**From:** Brenda Larsen  
**Sent:** Friday, August 30, 2013 8:09 AM  
**To:** Jeff Watson  
**Subject:** RE: Kittitas County Notice of Application SP-13-00008 Hanson Amendment

Re: Hanson Short Plat Amendment SP-13-00008

HANSON SHORT PLAT AMENDMENT  
 PART OF SECTION 16, T. 18 N., R. 19 E., W.M.  
 KITTITAS COUNTY, WASHINGTON

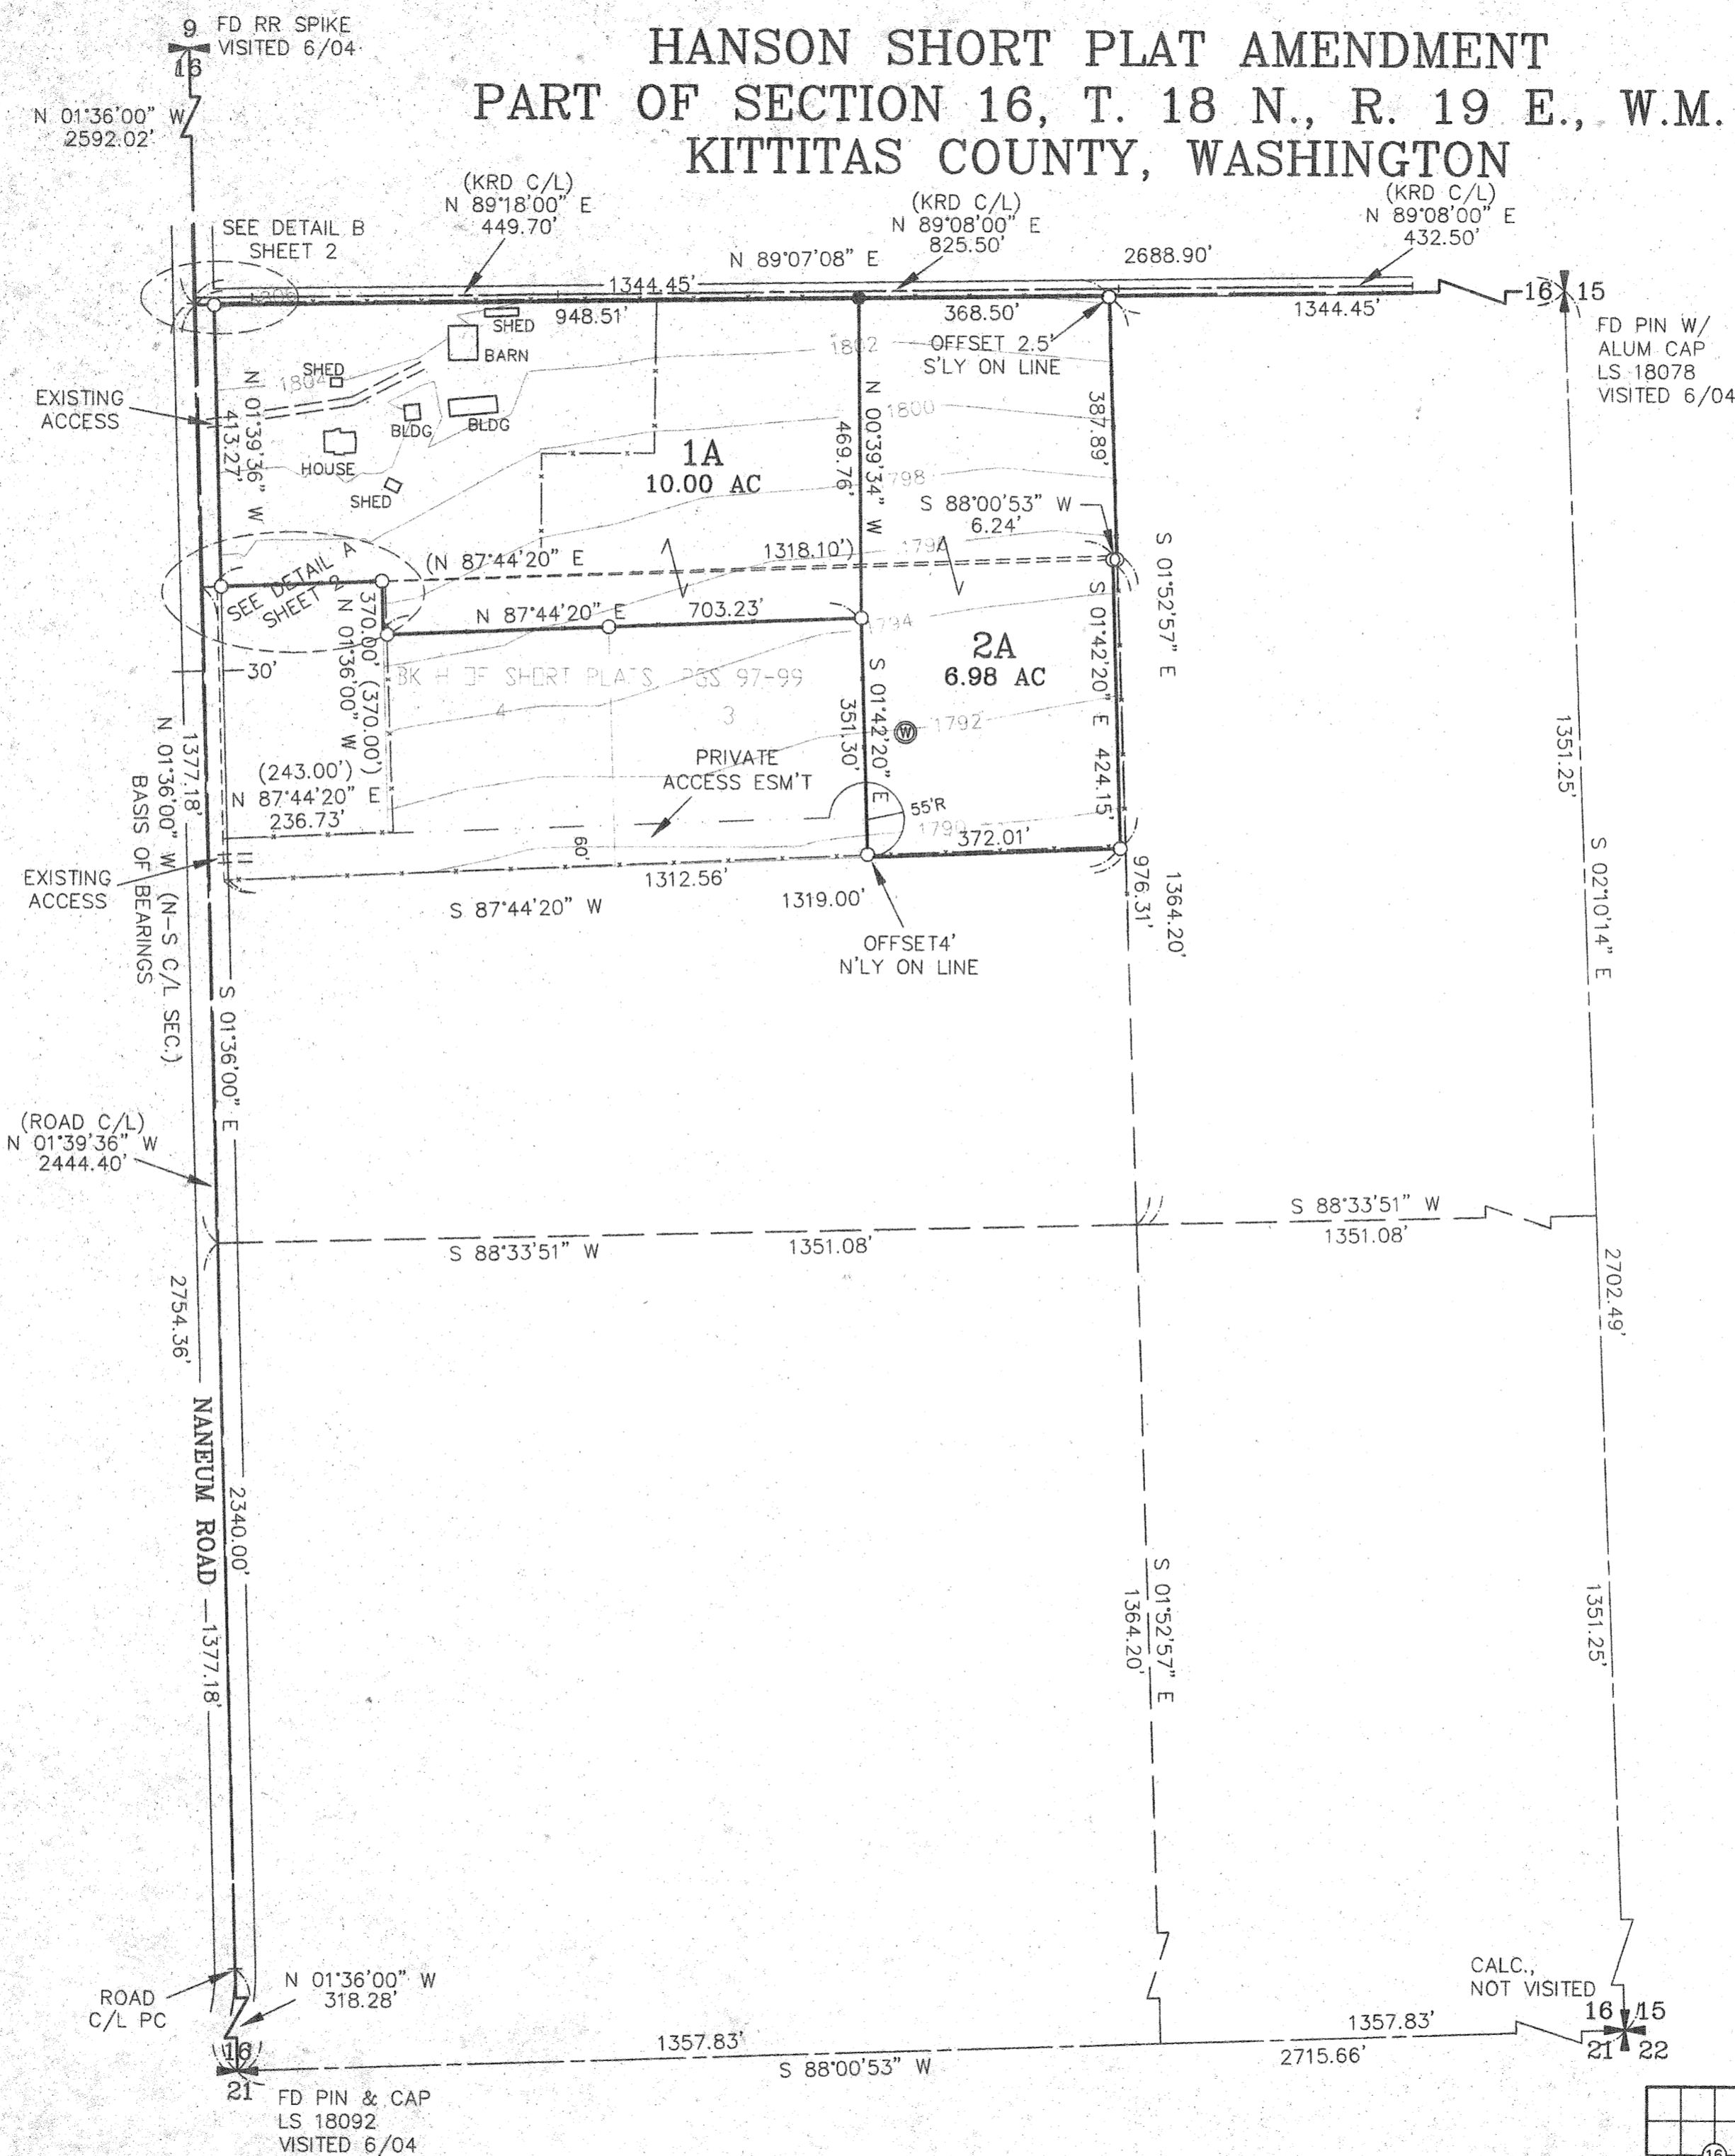
- The driveway(s) for the new property must comply with Kittitas County Code, i.e. any driveway greater in length than 150' shall be no less than 16 feet in width.
- The addresses shall be posted at the front of the property and easily visible from the road to emergency responders.
- All future development must comply with the International Fire Code.
